24th June 2020

Application No: R/92/20/PL
Site Address: 6 Manor Road Rustington BN16 3QT
Description of works: Demolition of existing garage & store on existing dwelling & erection of 2 No detached bungalows to rear.

Thank you for your internet representation made on 23rd June 2020 which has been recorded as an objection with the comments as follows:

REVISED SITE PLAN CHANGES:

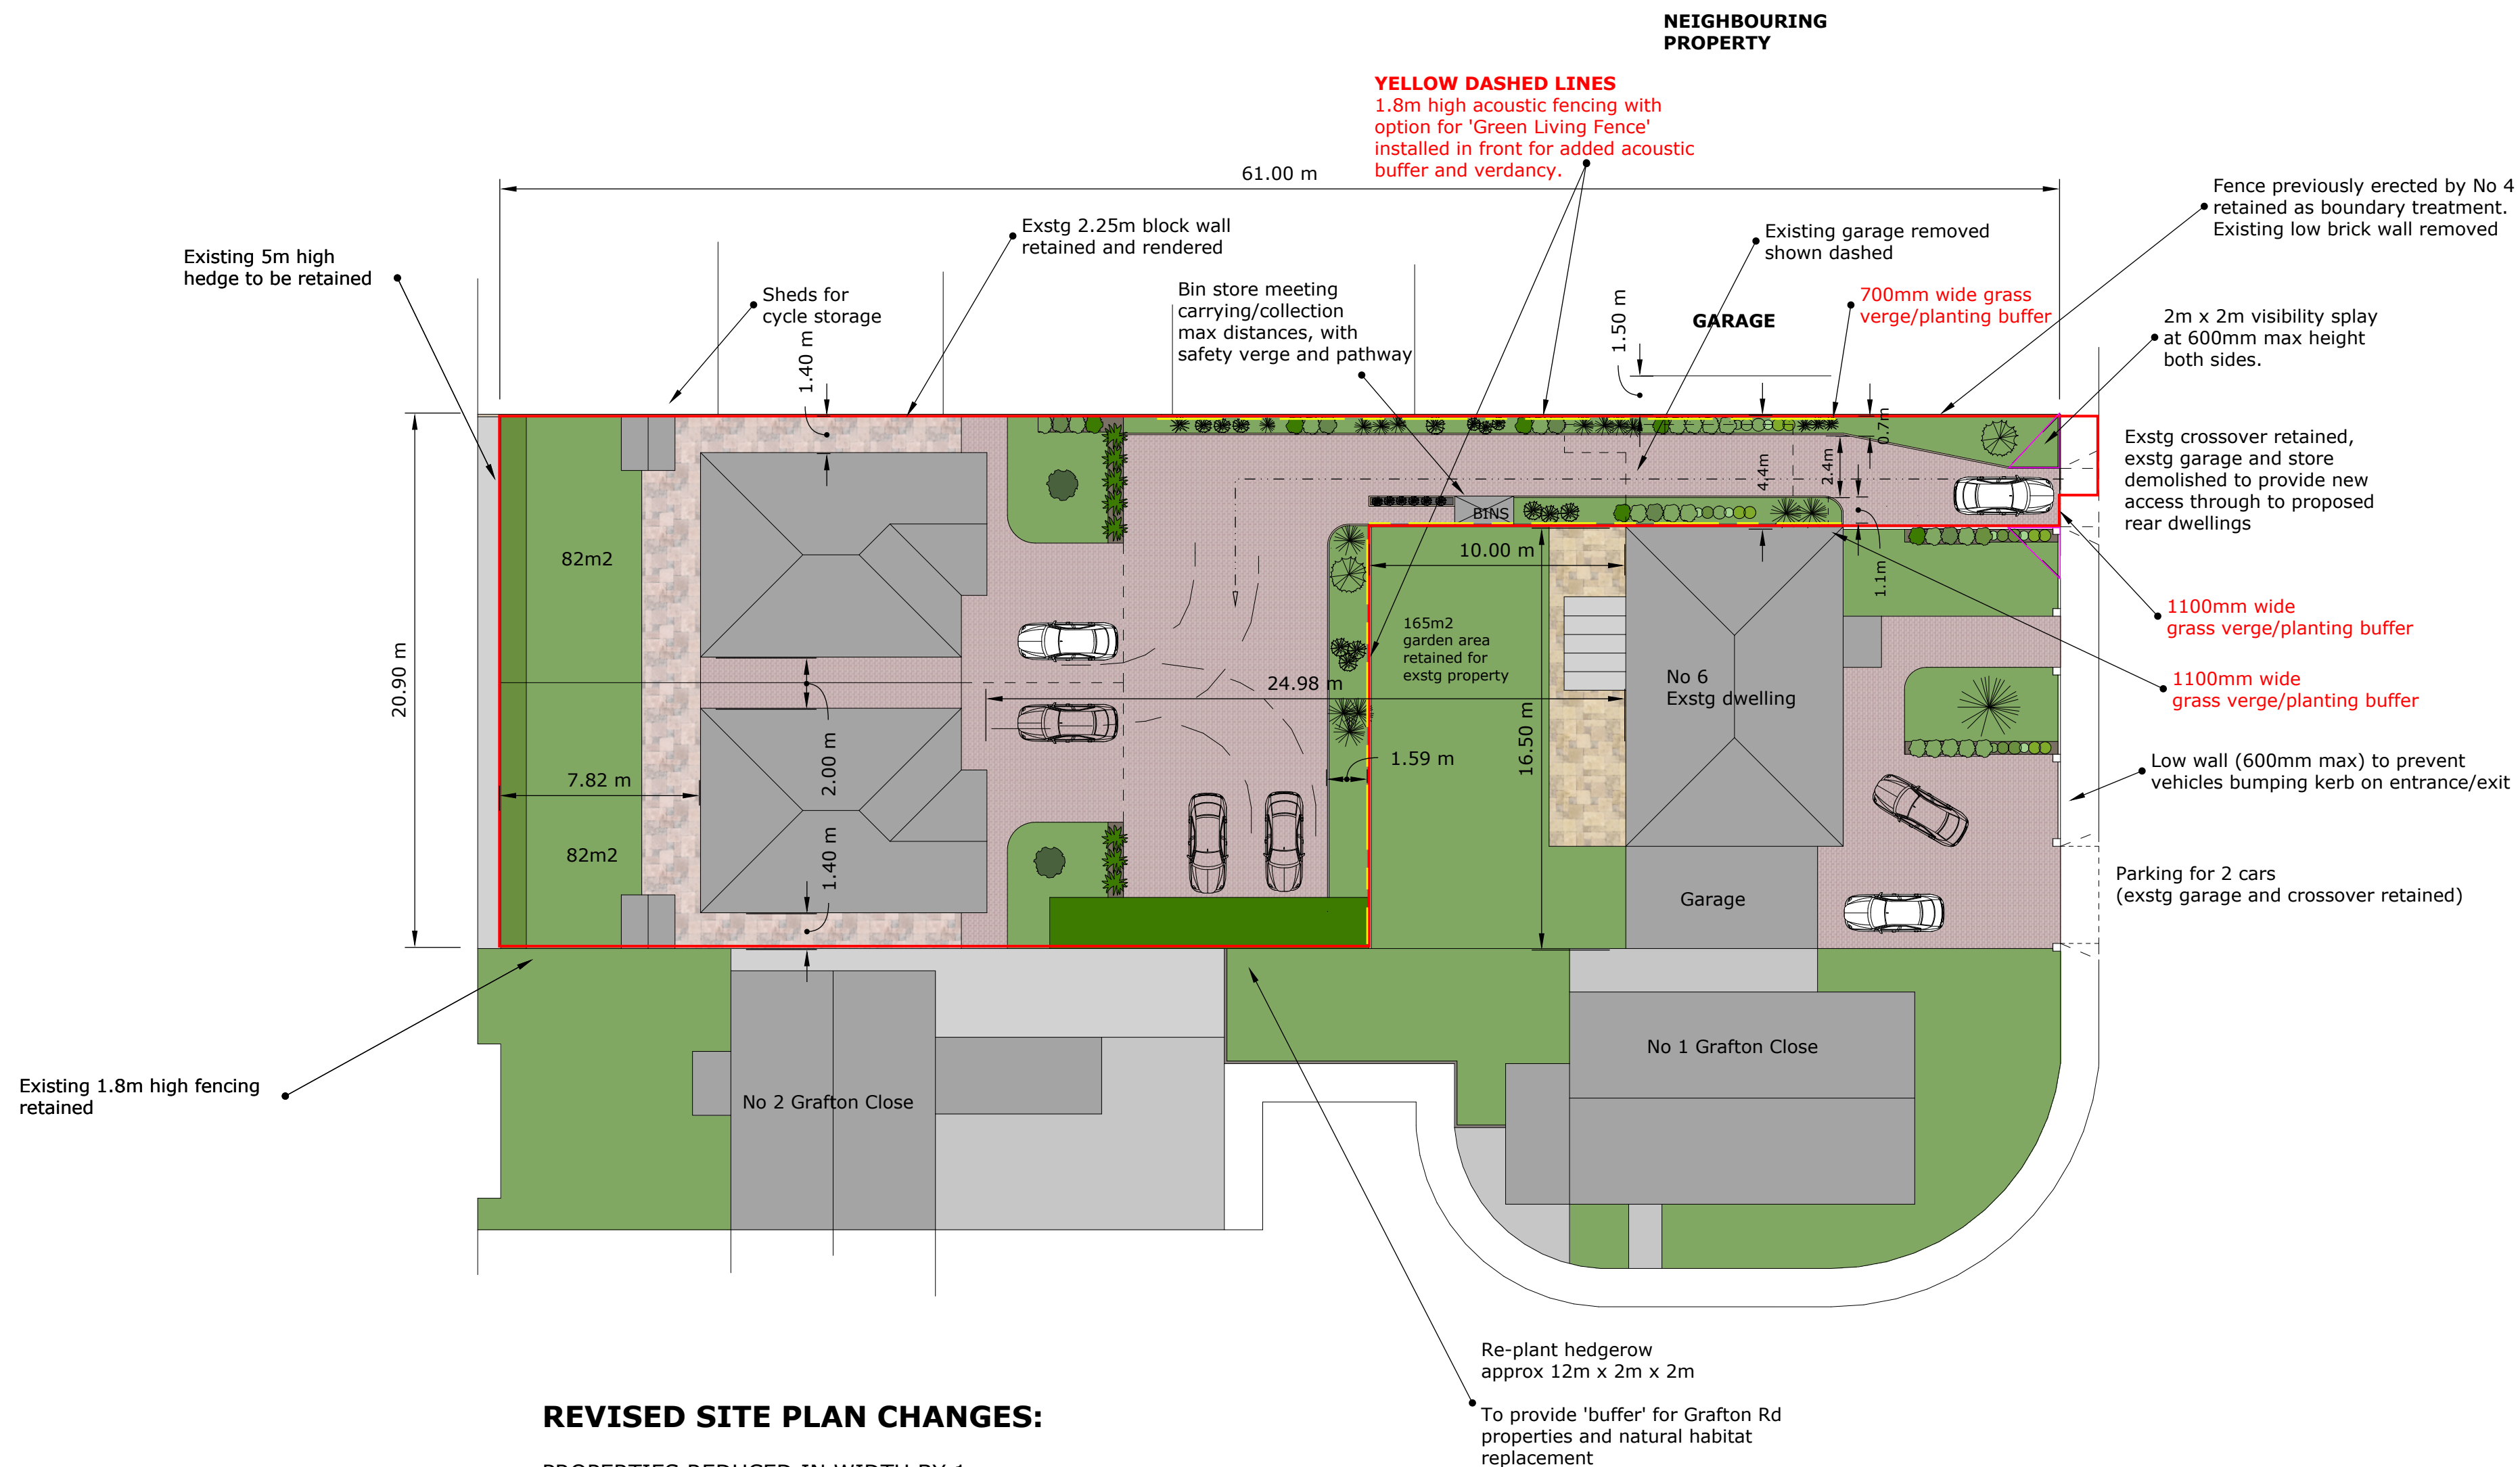
The Proposed Site Plan shows '1.8m high acoustic fencing with option for 'Green Living Fence' installed in front for added acoustic buffer and verdancy.' It has been agreed (6.17) in the Planning Support Statement that acoustic fencing (6.15) 'will be secured by way of proposed condition 5', however, this only requires that (6.16) 'No development above damp proof course (DPC) level shall take place until details of acoustic fencing to the side boundaries of the access have been submitted to and approved by the Local Planning Authority and the new dwelling shall not be occupied until the approved acoustic fencing has been erected' To ensure that (RNP 4.12) 'Development not impact on surrounding properties .. and alleviate possible noise issues to existing neighbouring properties' the acoustic fencing should be required to be in place before building work commences, not just before the new dwelling can be occupied.

The addition of a 'Green Living Fence' should be made a Condition in addition to the acoustic fencing in order to increase the 'acoustic buffer and verdancy' and to replace the shrubs and plants that were ripped out when the garden was cleared in advance of the planning application being submitted.
